ABLE MARINE ENERGY PARK (MATERIAL CHANGE 2 – TR030006)

UPDATED ENVIRONMENTAL STATEMENT

CHAPTER 4: DESCRIPTION OF CHANGES TO DEVELOPMENT & ALTERNATIVES

SLR Ref: 416.01148.00005
Version No: FINAL
June 2021

Scale:	Drawn By:	Checked By:	Approved By:
NTS@A1	D Almeida	R Crum	R Crum
Date:	07/12/2020	12/02/2021	12/02/2021
Drawing No:	AME-036-10009	Revision:	C

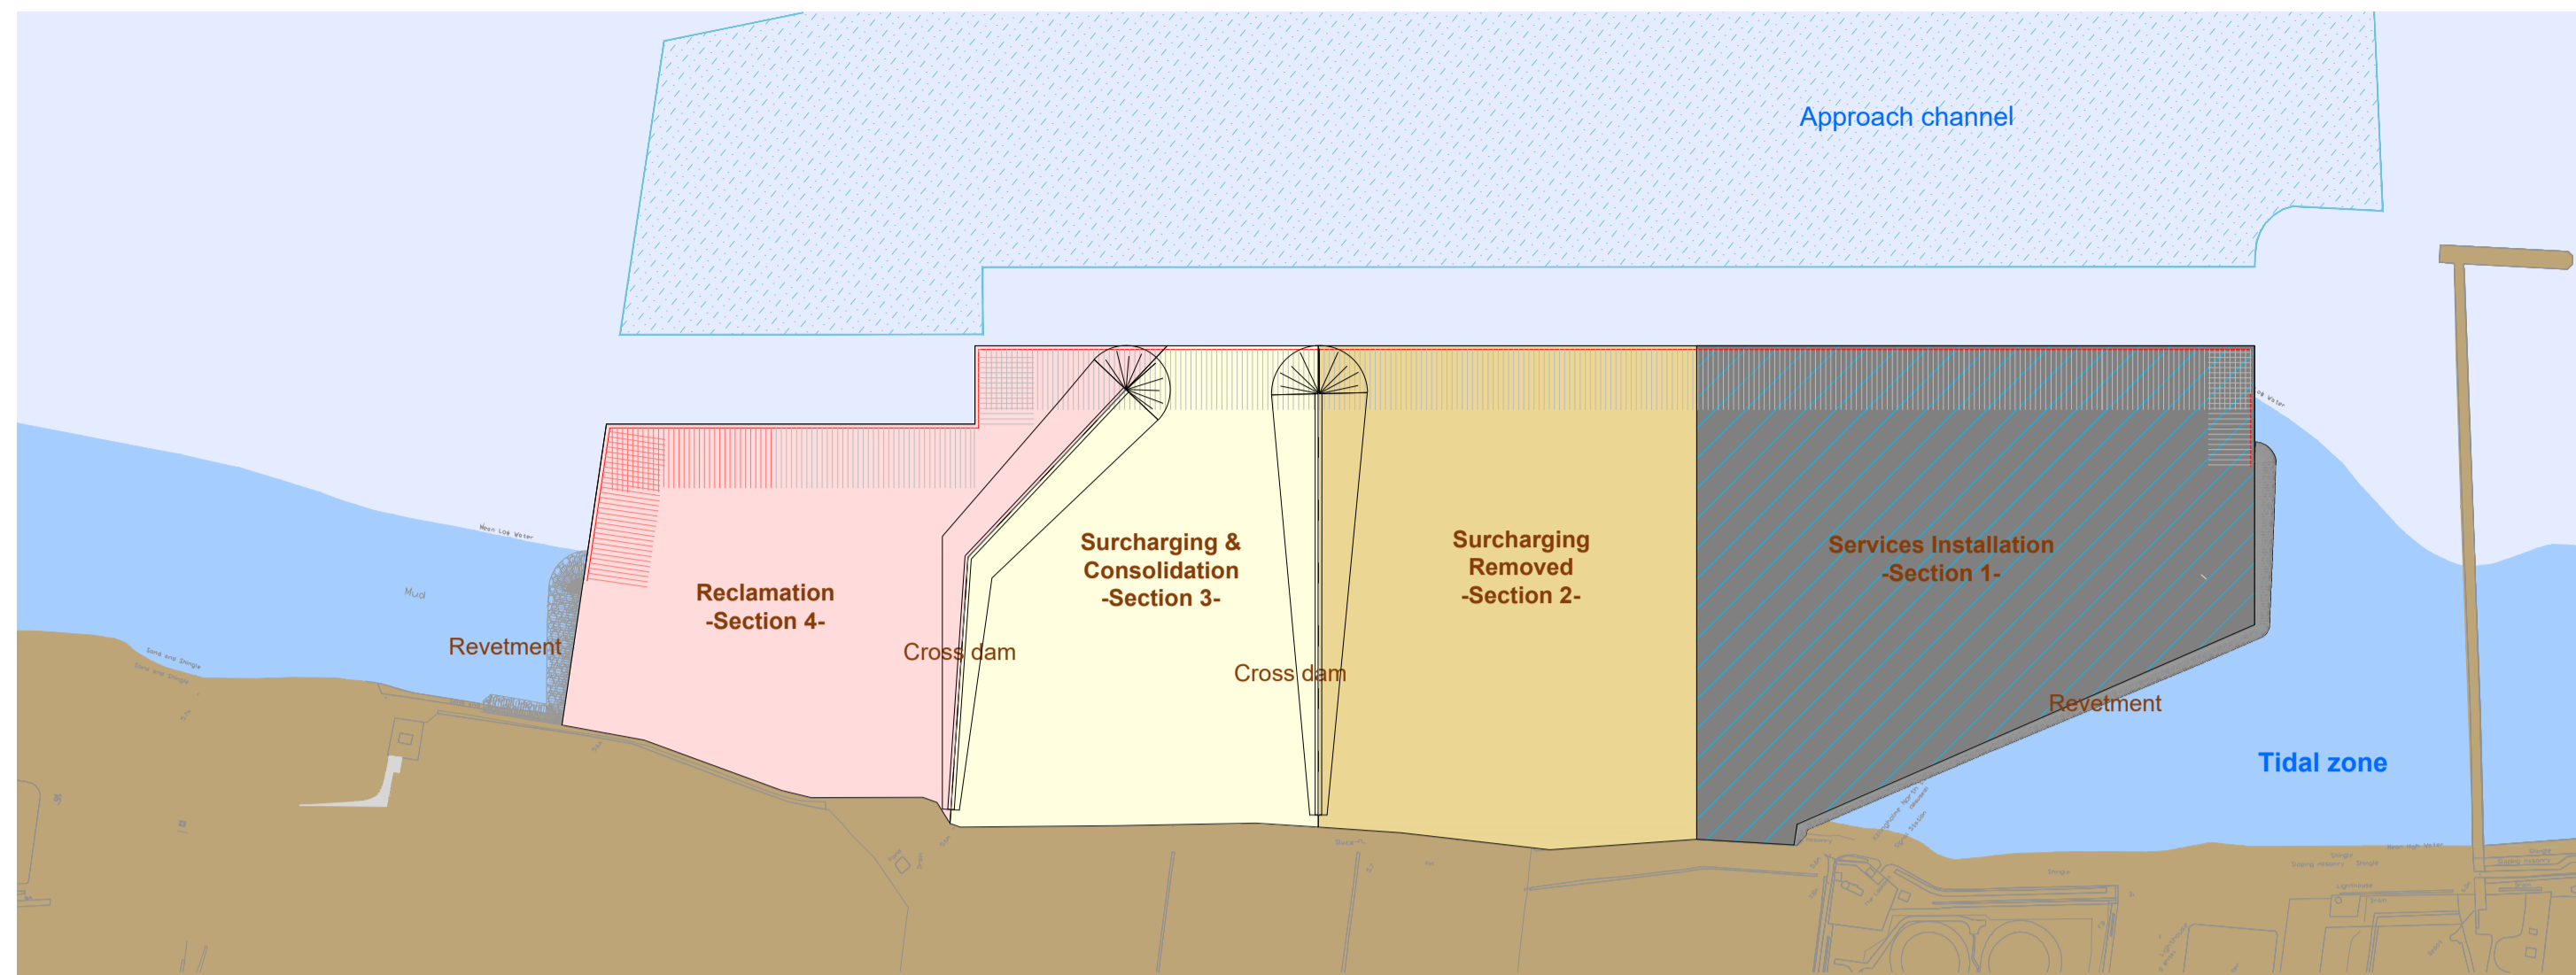
- 4.3.15 In order to facilitate early handover of an operational section of quay, the works are now proposed to commence at the southern end of the quay and progress northwards. On this basis, the construction sequence shown on the DCO approved drawings AMEP_P1D_D_101 to 103 is proposed to be amended, and thereby superseded, by the alternative sequence shown on application drawings AME-036-10009 to 10011 which are included in Appendix UES4-1.

Consented Rail Crossing Point

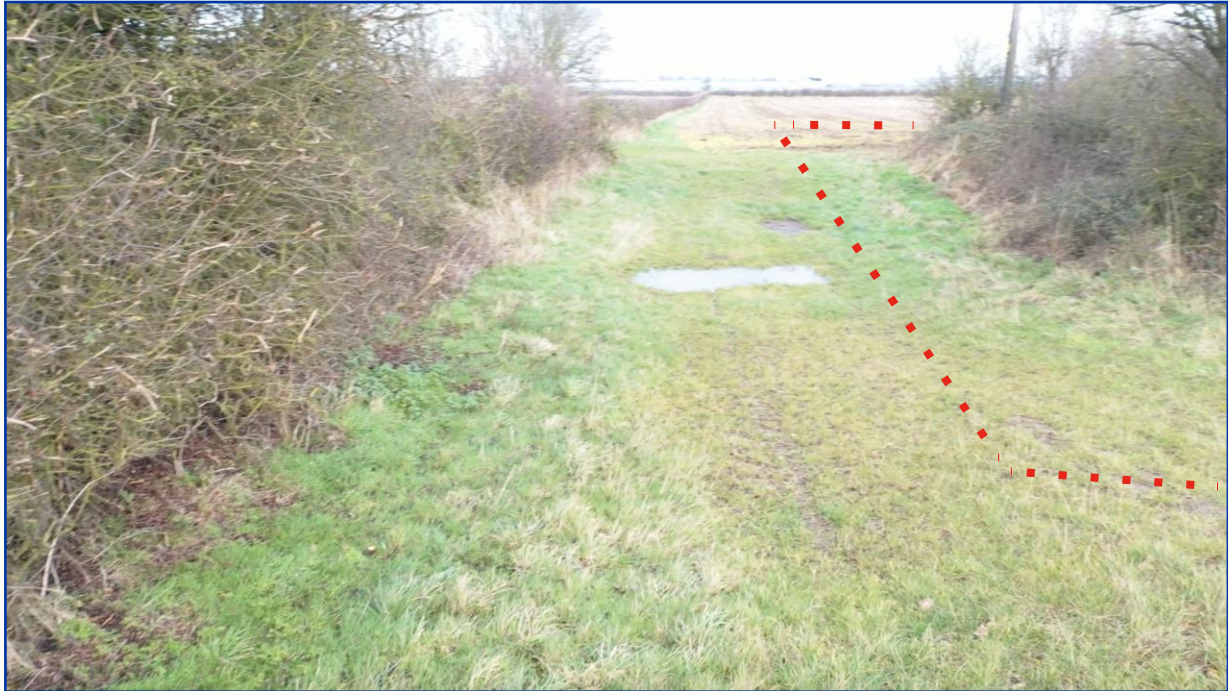
- 4.3.12 Schedule 5 of the DCO (Technical Appendix UES1-1) authorises the diversion of two public footpaths; the diversion routes are shown on the approved Rights of Way Plans. A minor amendment is proposed to the diversion of Footpath 50 in the district of North Lincolnshire.
- 4.3.13 The change to the diversion is desirable in order to avoid the diversion crossing the Killingholme Branch railway where the railway is still technically operational, albeit that it is many years since any train has actually passed over the tracks at the authorised crossing point.
- 4.3.14 The authorised crossing point is shown on Rights of Way Plan Sheet No. 5¹² and is also shown in Figure 4-4 below together with the proposed alternative route. The proposed amendment is further shown on drawing AME-036-00004 included in Appendix UES4-1.
